**WEST SUSSEX COUNTY COUNCIL
 STRATEGIC PLANNING CONSULTATION**

SUBJECT: R/55/12/TEL-Prior notification for installation of dark green DSLAM cabinet

Land opposite, 67, The Street, Rustington, West Sussex

RECOMMENDATION:

RUSTINGTON - PCP 4 - SCALE 1:200

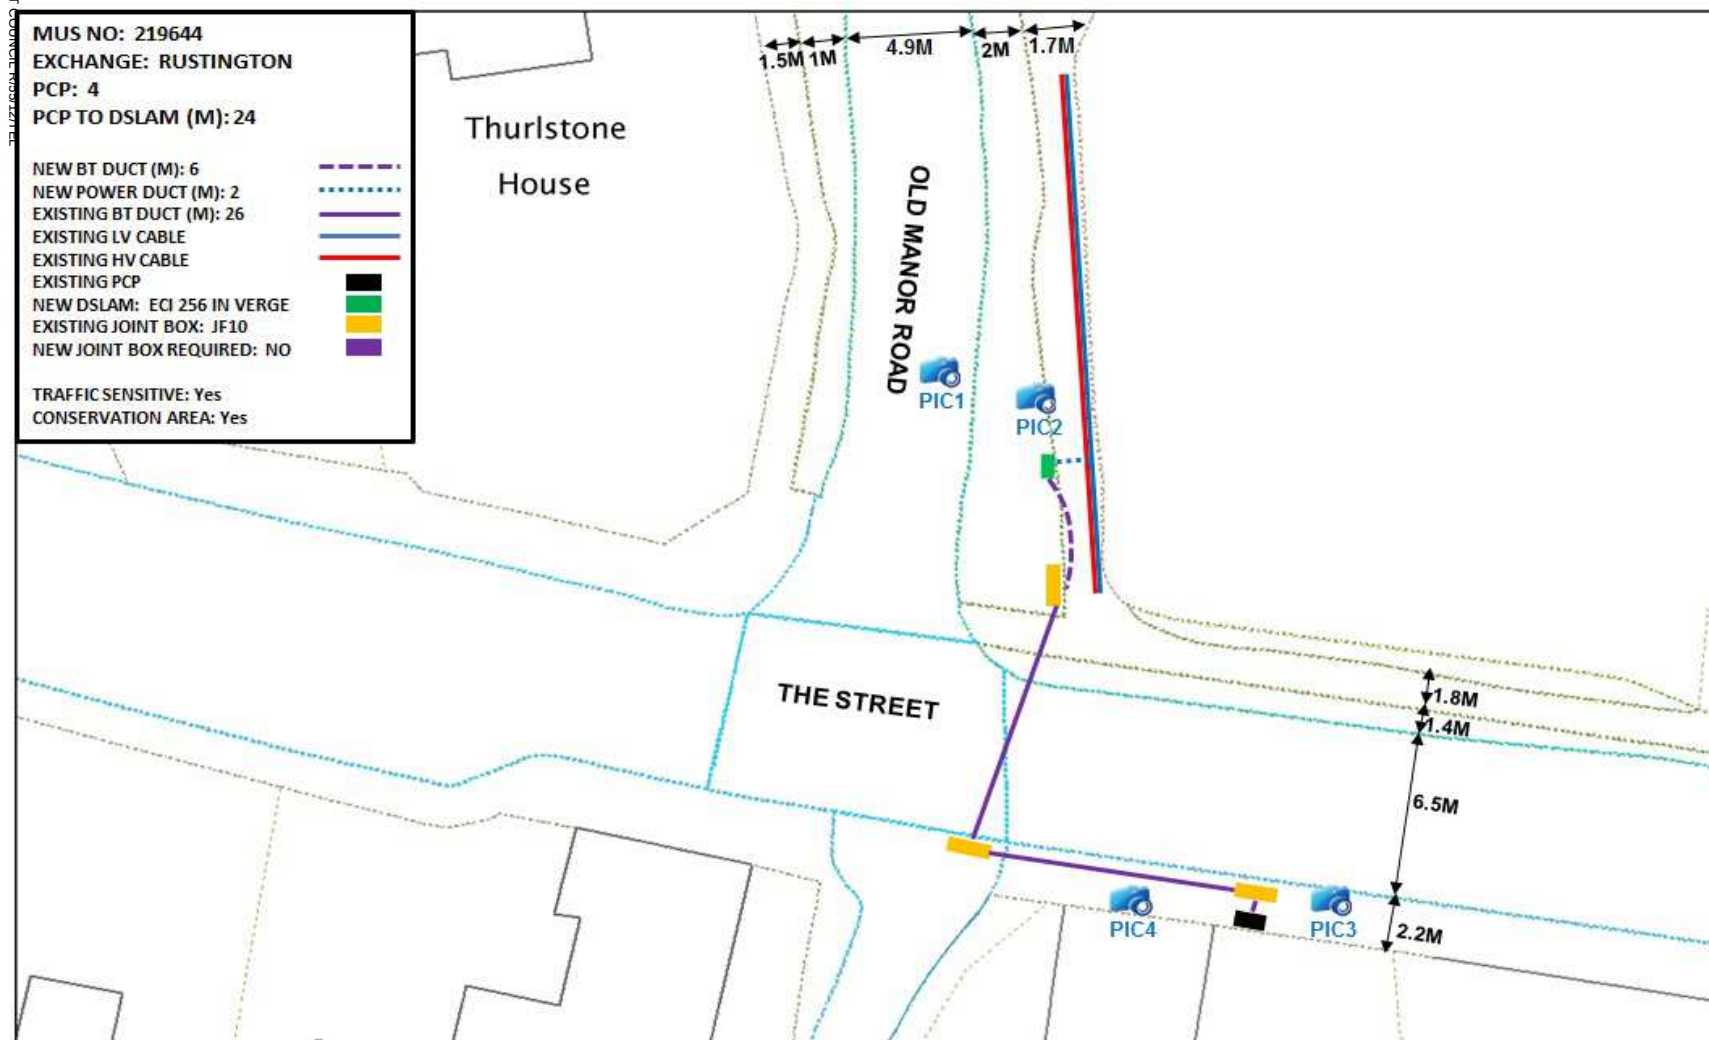
The works do extend over the public highway, and as such traffic management may be required whilst the works are being undertaken. The Statutory Undertaker will also need to submit the necessary notification to the Highway Authority independently and any traffic management will also need to be agreed with the WSCC Coastal Team prior to works taking place.

The applicant is advised to contact the Coastal Team, Community Development and Big Society, Communities and Infrastructure Directorate, Centenary House, Durrington Lane, Durrington, Worthing, West Sussex BN13 2QB to obtain a license for the works on the highway.
